**Consultation Response from KC,
Lead Local Flood Authority**

2023/91002 Corby, Birkby Road, Birkby, Huddersfield, HD2 2DR

Date Responded: 27th April 2023

Kirklees Flood Management & Drainage would like FURTHER INVESTIGATION and INFORMATION regarding the culvert that crosses site.

client  
Dr N Gilkar  
project  
Corby, Birkby Road, Huddersfield, HD2 2DR  
drawing  
Existing and Proposed Site Plans

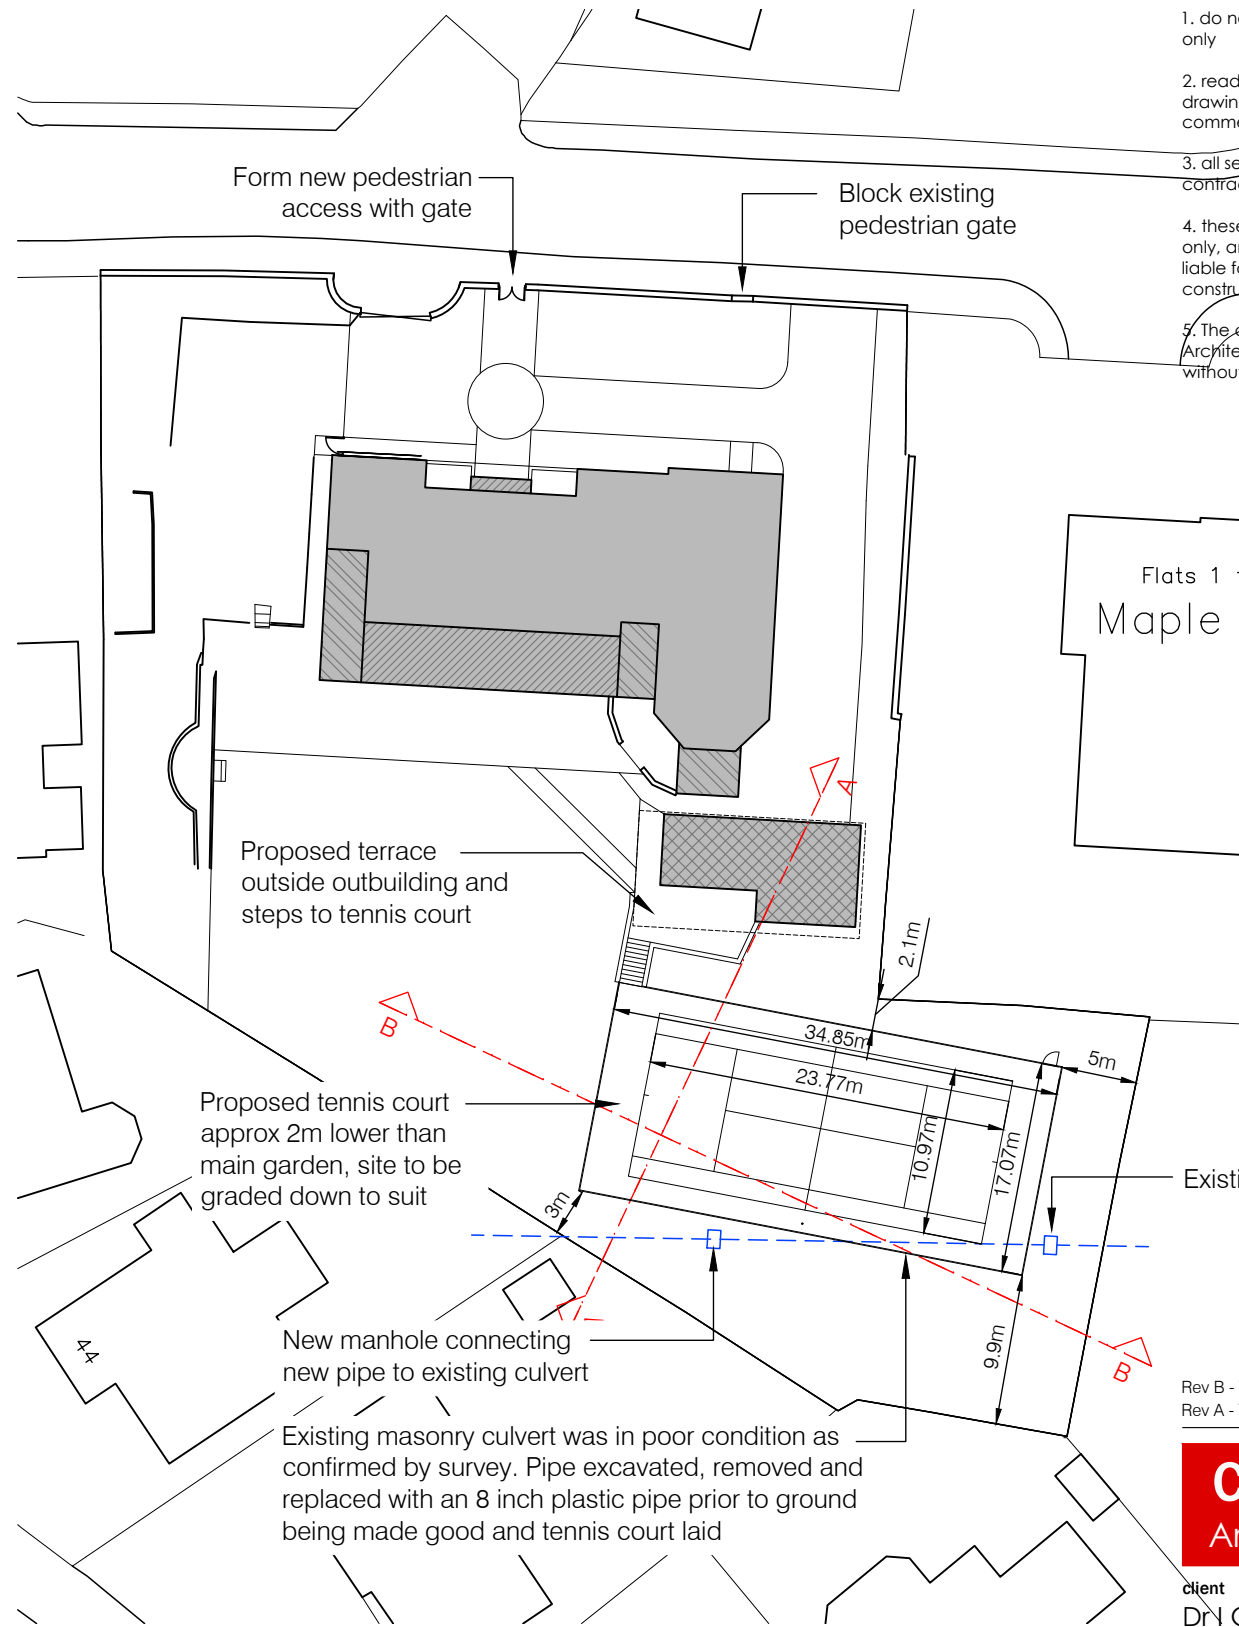
The exact route, condition, depth, and survey of current access points (manholes) is required. There is no conflict with extensions to the main property, but we advise that any remedial work from the condition survey is agreed prior to building over with the tennis court and that compaction work will not endanger the culvert. Access points may conflict with the court itself and an alteration in location of the court or work on the culvert to create access in more suitable locations, may be required.
